**Letter of Intent**  
**Falcon Landing**

The request is to update the approved site development plan to today's standards, because the site was not developed and the cd's & plans expired. What are you proposing? How big is the building? What is it to be used for? What is the address of the property?

EXTERIOR ELEVATIONS
 DATE: 11.29.18
 DRAWN BY: CDGPS
 CHECKED BY: TDG
 PROJECT NO:
 SHEET:
9 OF 9

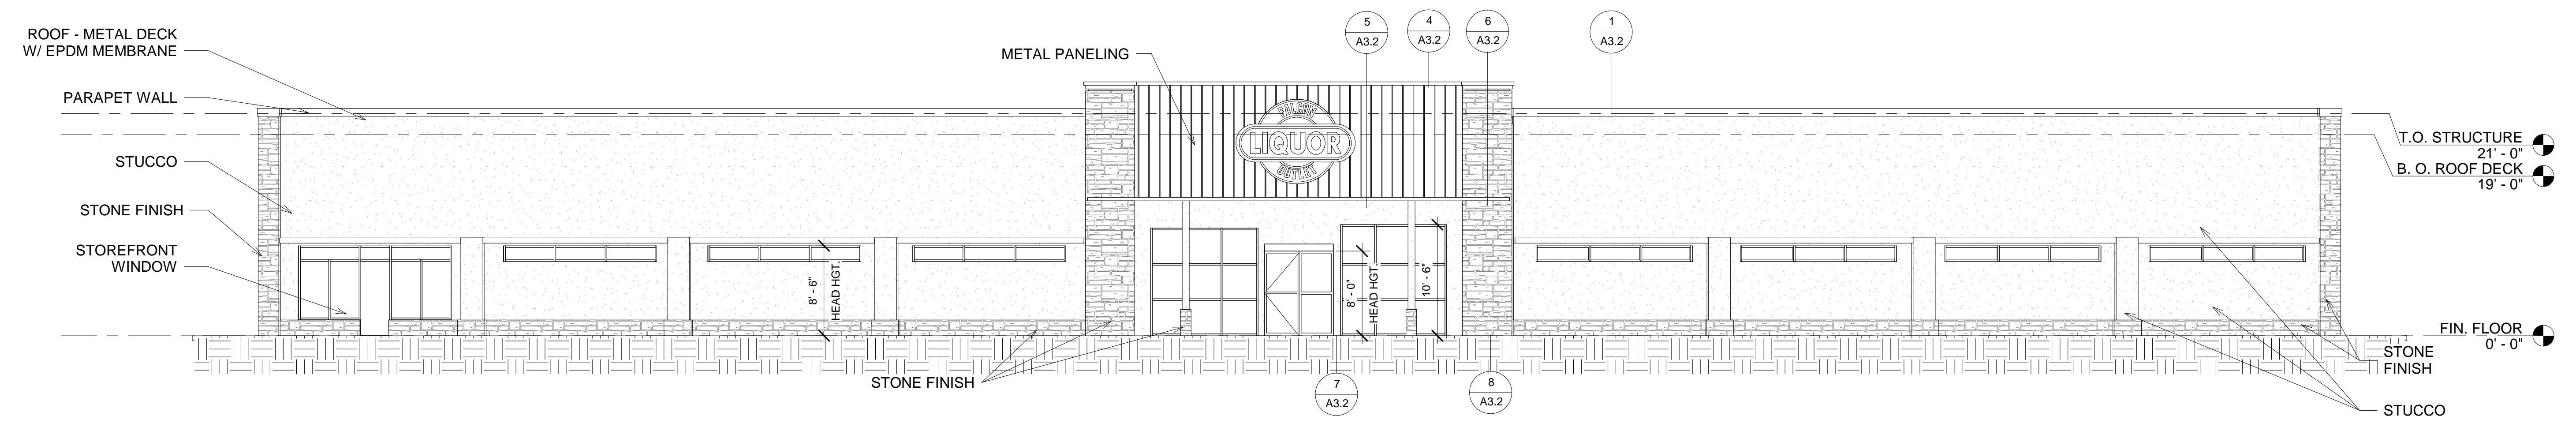
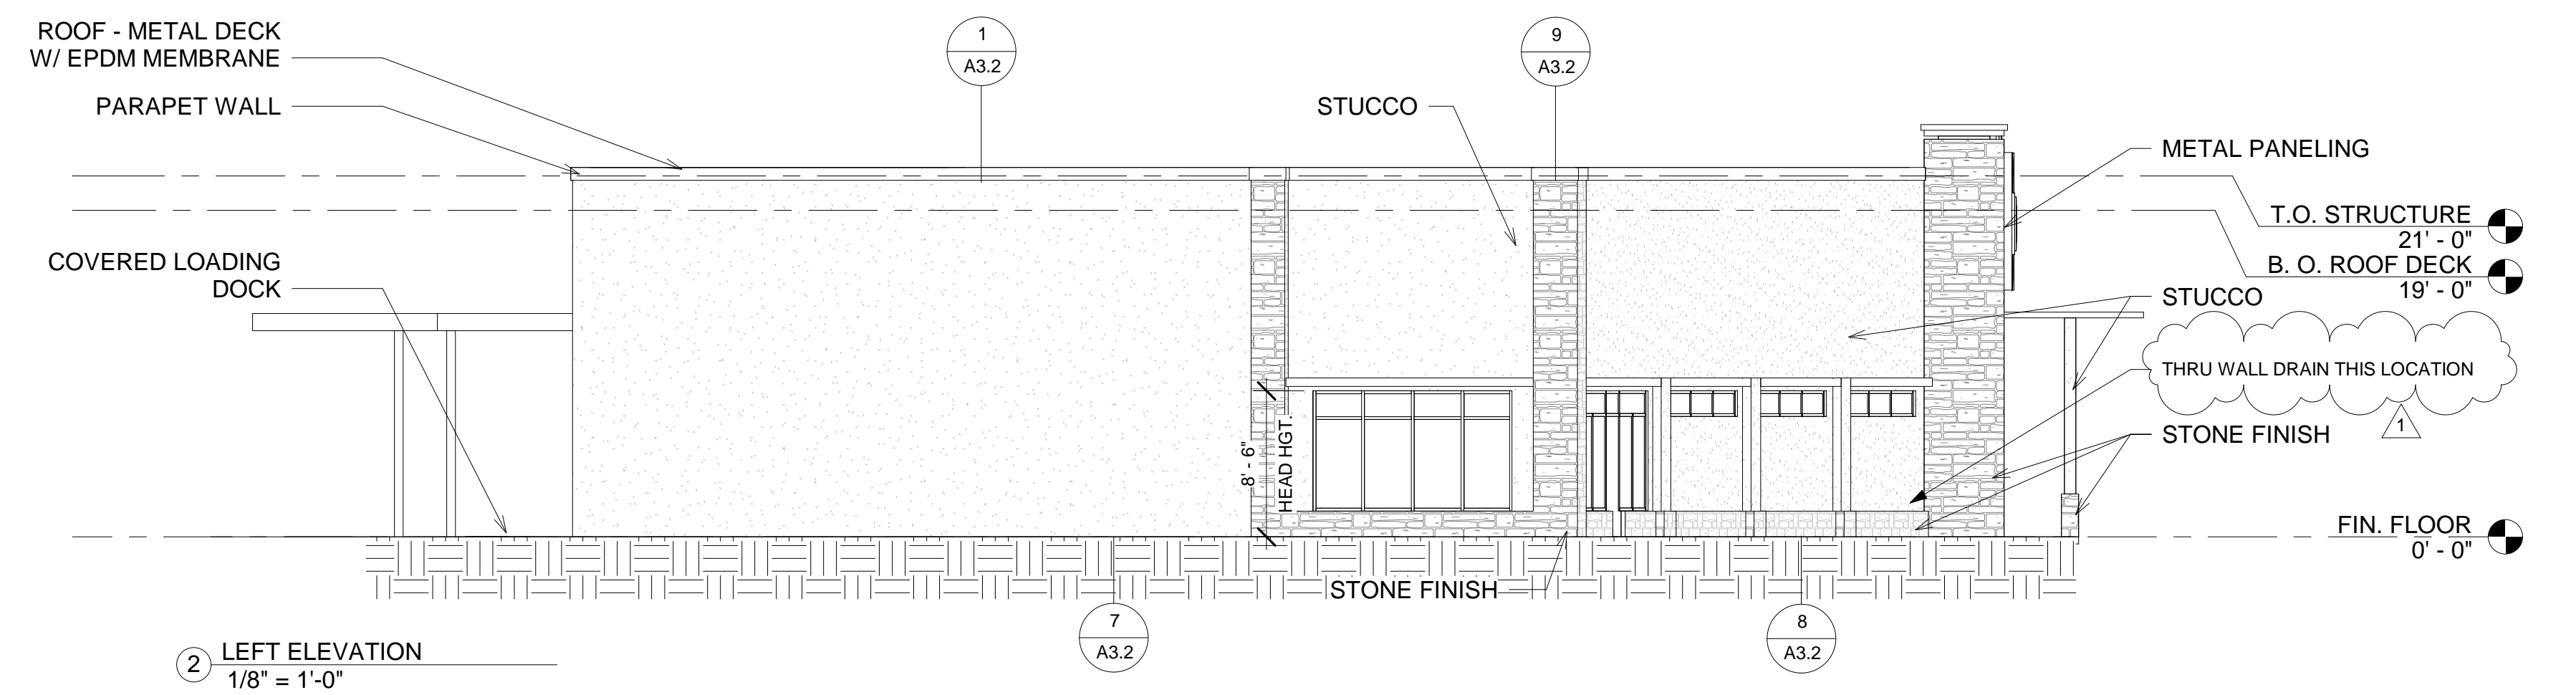
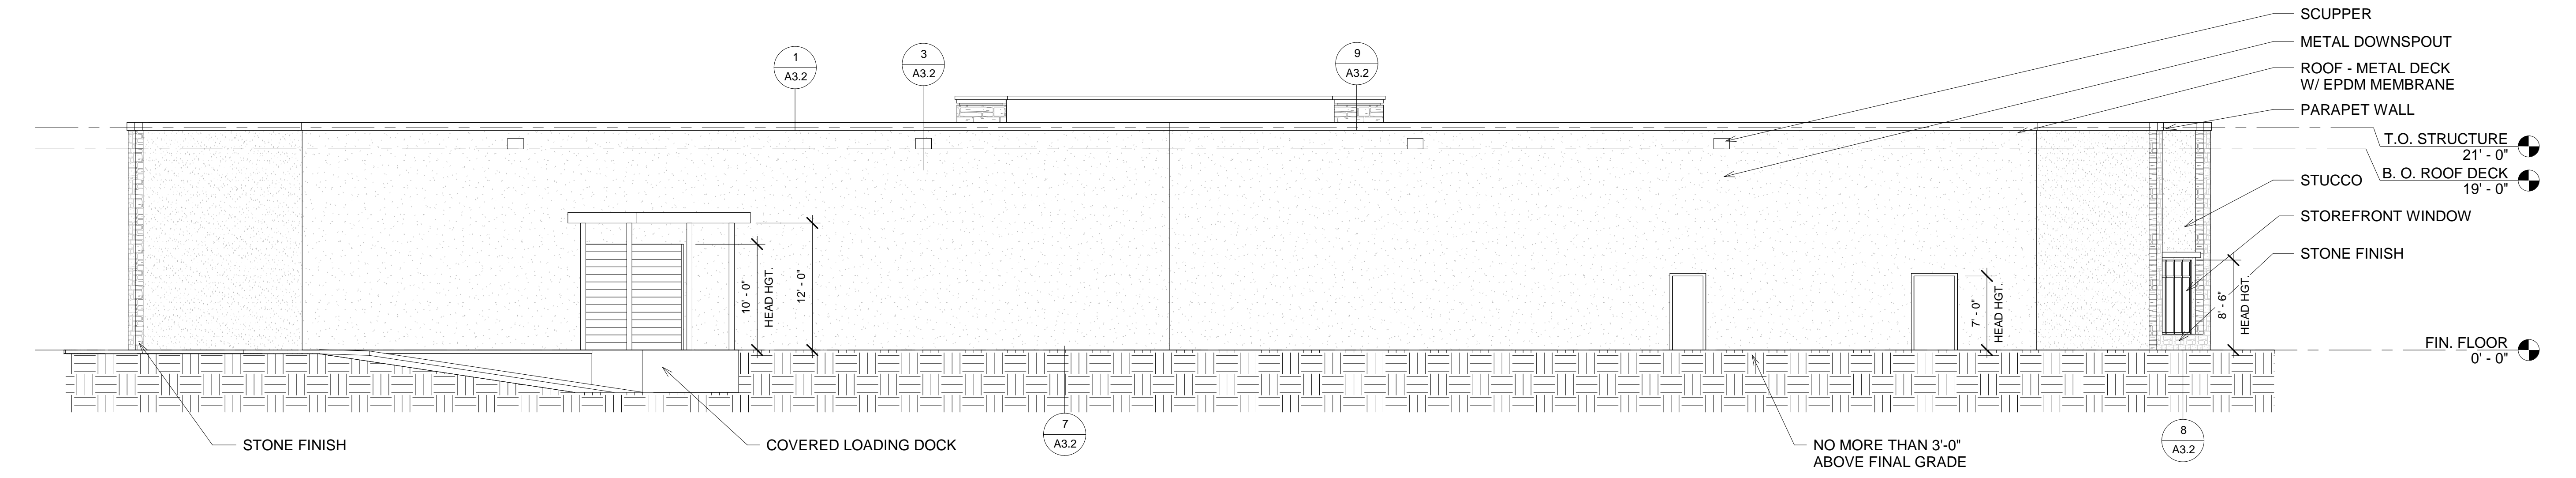
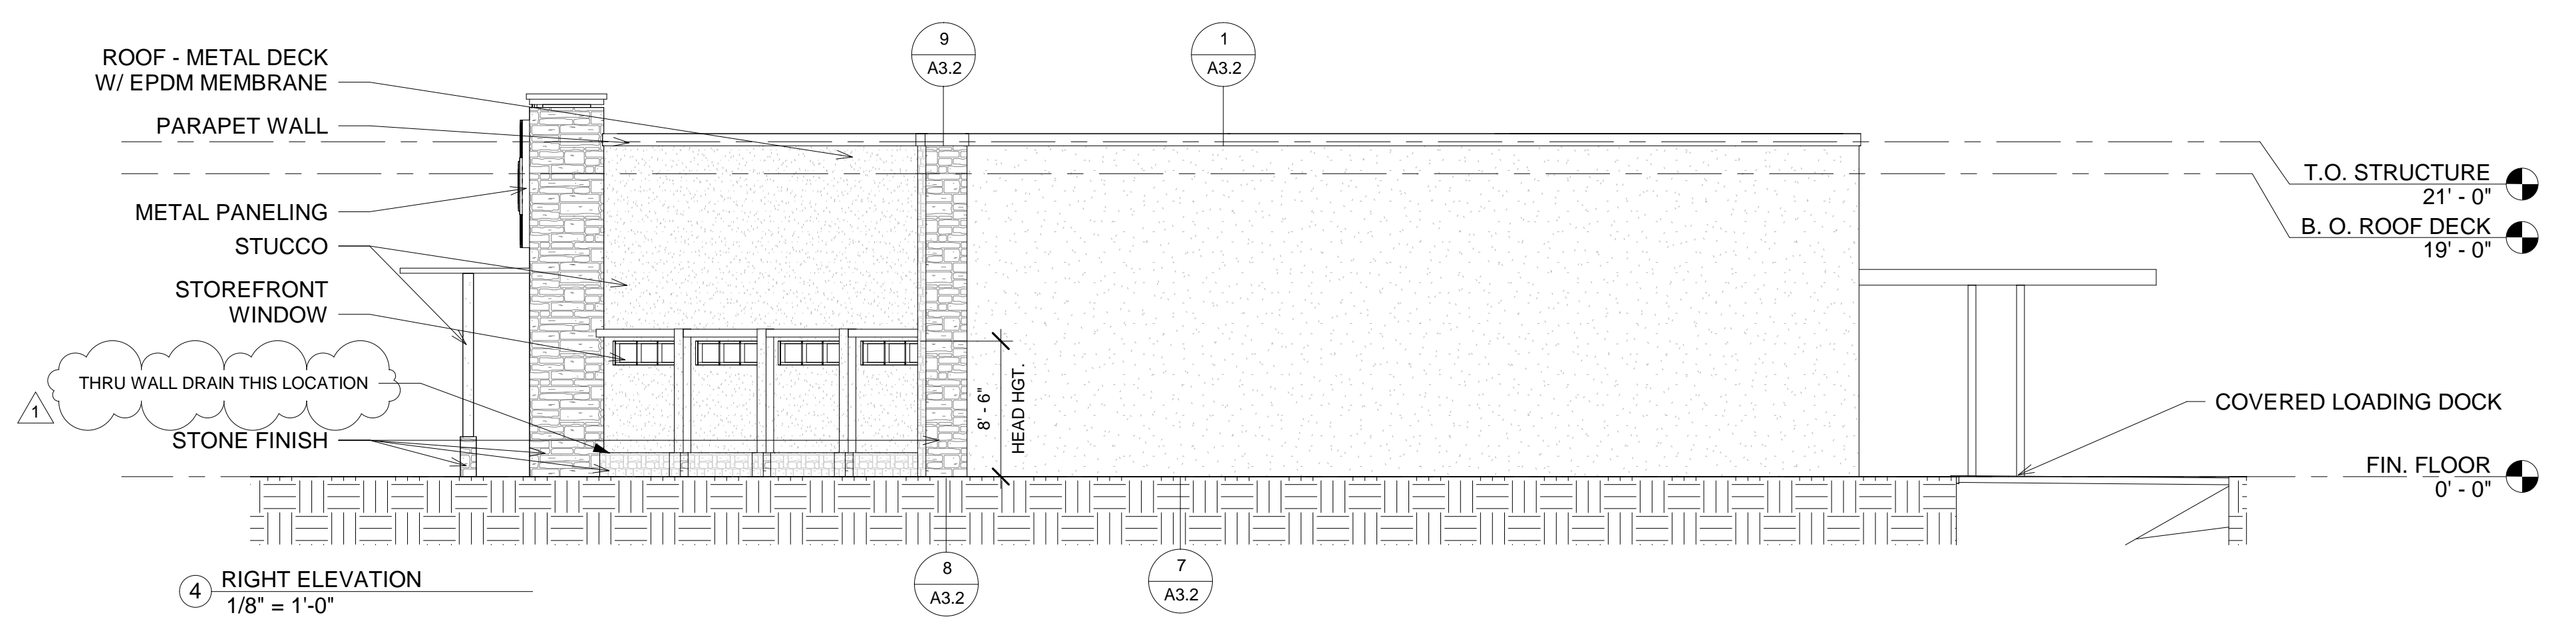
Are the elevations correct? They appear to be only a portion of the building as depicted and they may not match the footprint of the building.
